**re: Grading Plan Review and Geotechnical
Recommendations
Proposed Multi-Storey Building**
294-300 Tremblay Road, Ottawa, Ontario

date: October 6, 2023

file: PG5407-MEMO.01 Revision 3

Drawing Title: **SITE GRADING, DRAINAGE, SERVICING AND EROSION & SEDIMENT CONTROL PLAN**

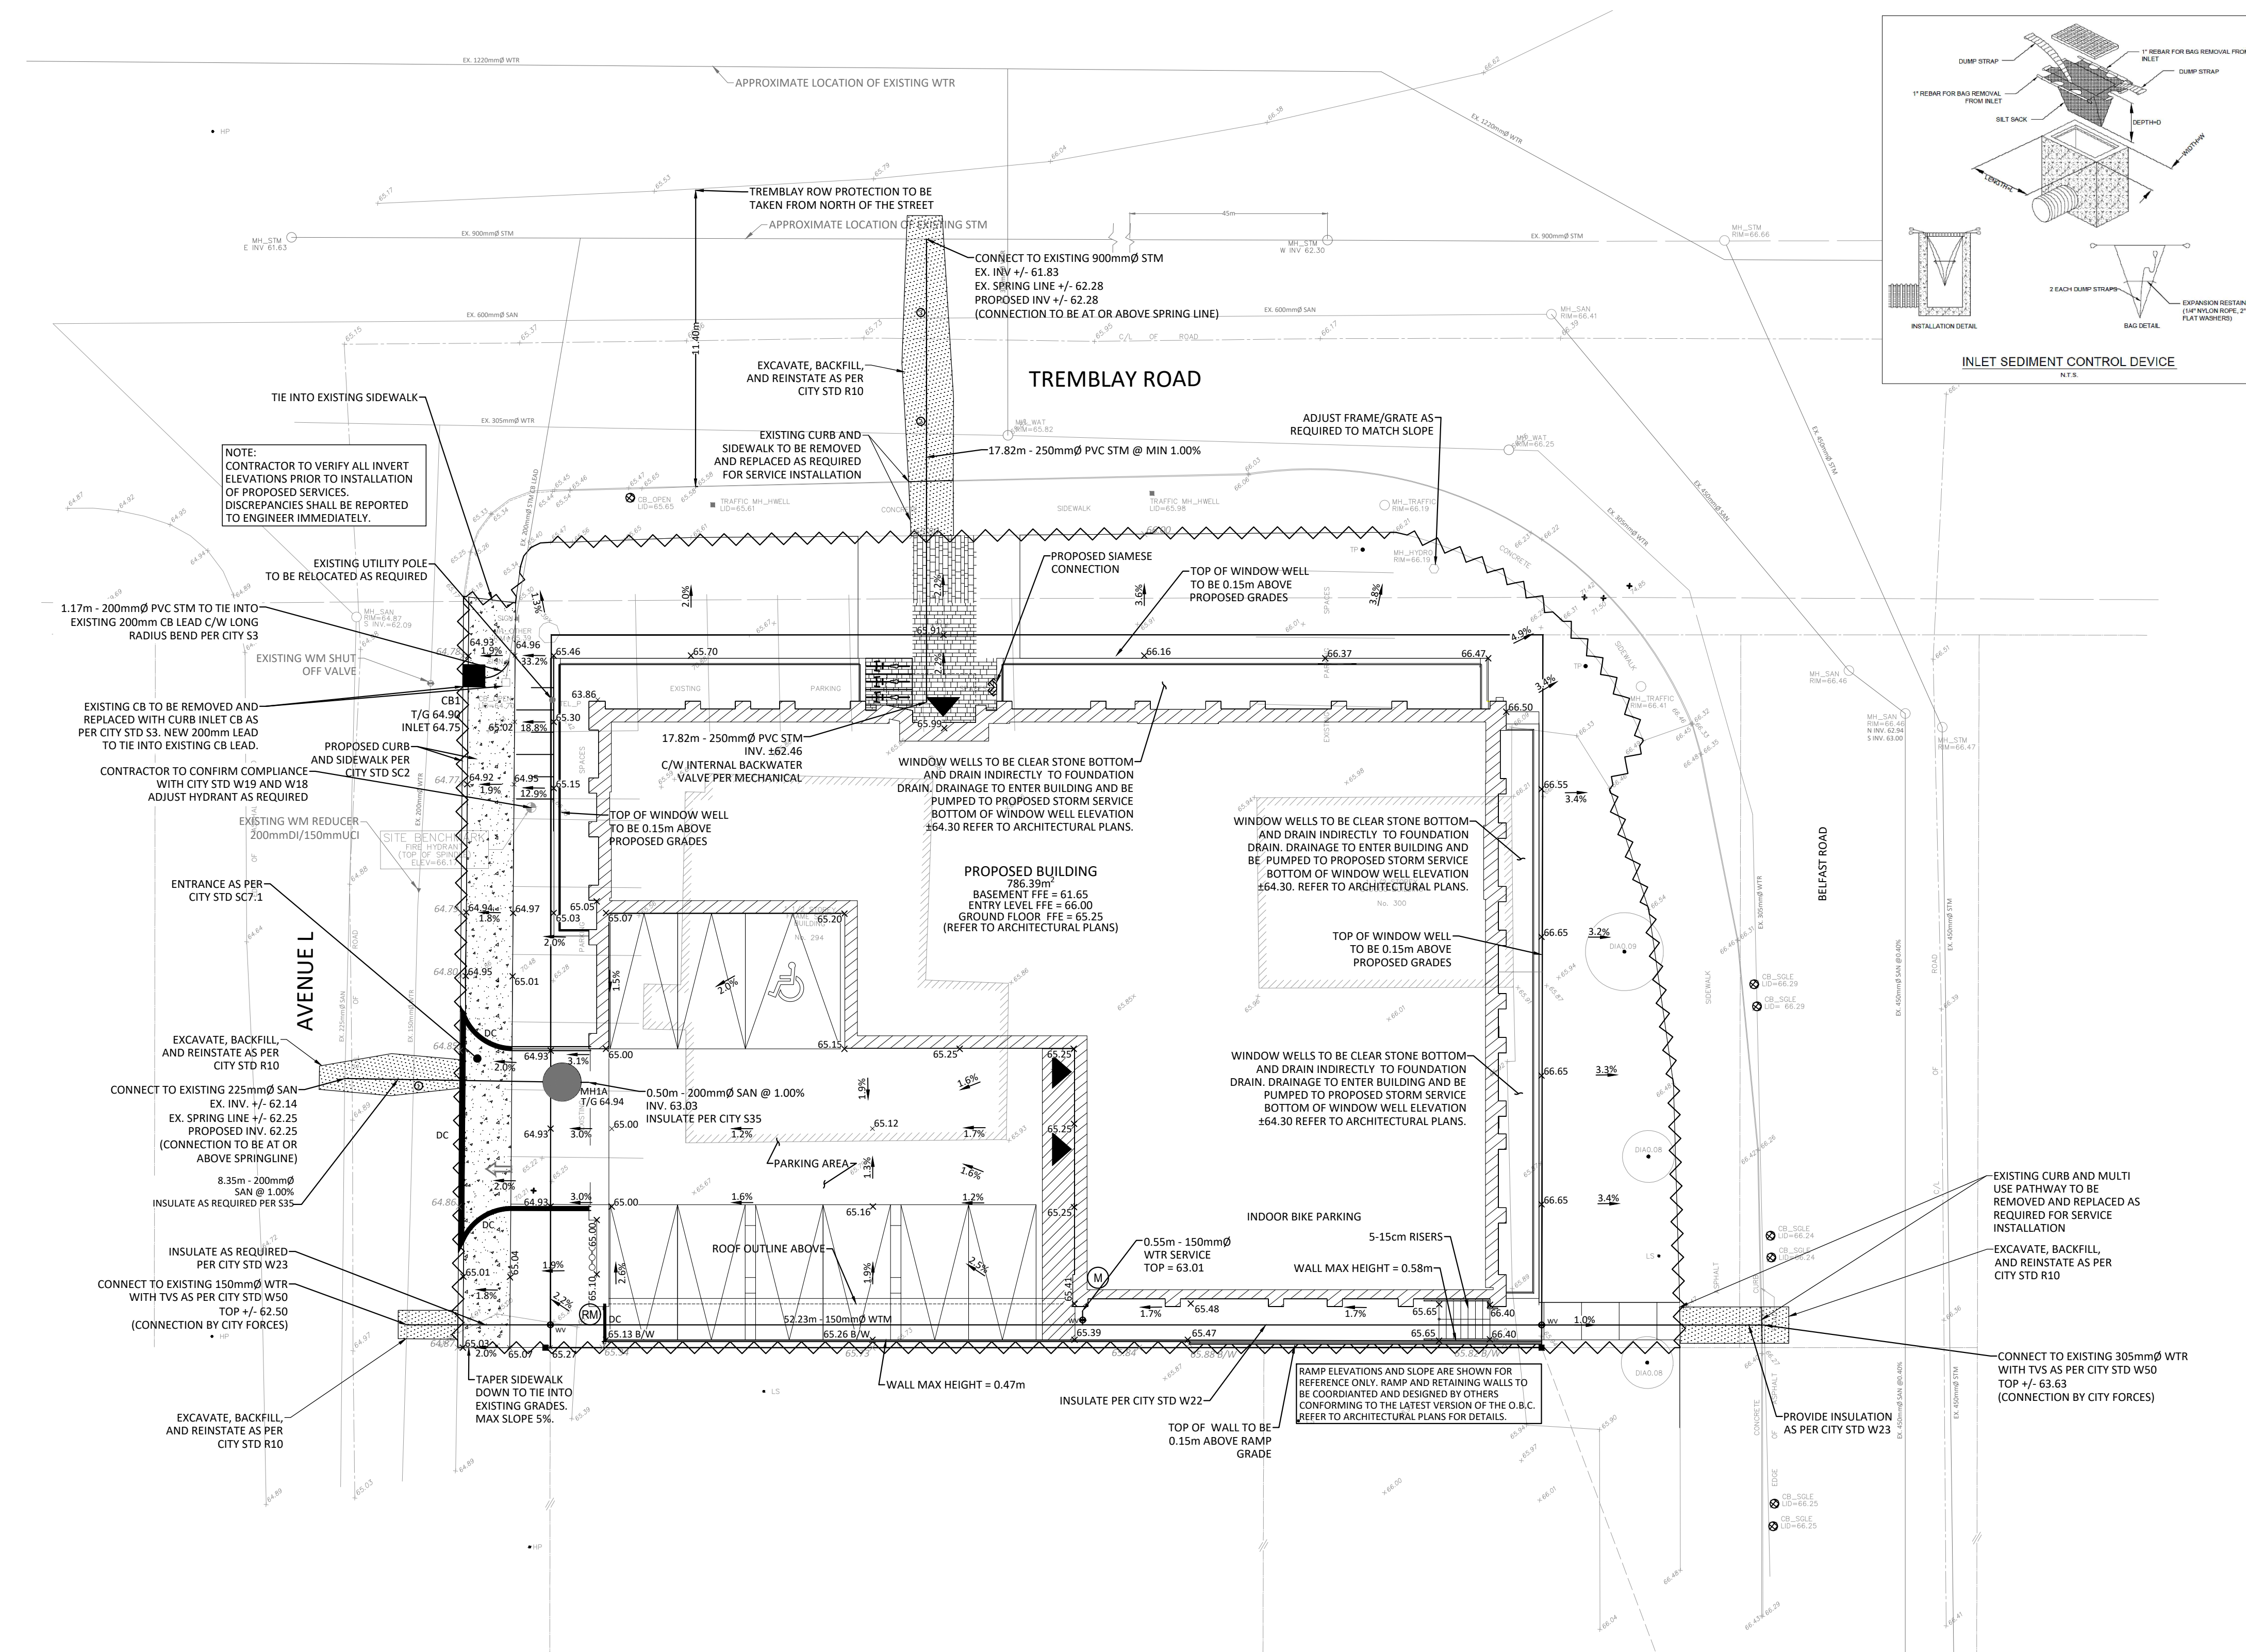
Based on our review of the above noted drawings, it is understood that no major grade raises are anticipated for the subject project. It is further noted that due to the absence of a sensitive silty clay layer, no permissible grade raise restriction is applicable for the subject site. Furthermore, the majority of the subject site will be excavated to accommodate for the underground parking structure. Therefore, based on our review of the above noted drawings, the proposed grades are considered acceptable from a geotechnical perspective and no additional measures such as lightweight fill or settlement surcharge programs will be required at the subject site. However, based on our review, the proposed window wells were noted to be provided with a reduced soil cover for footings of heated and unheated structures against frost action.

As for our review of the proposed site servicing plans, the services were found to be outside of the lateral support zone of the proposed footings and are considered to be acceptable from a geotechnical perspective. Furthermore, the frost protection cover provided for the service pipes was noted to be in marginal agreement with the minimum required frost soil cover of 1.8m.
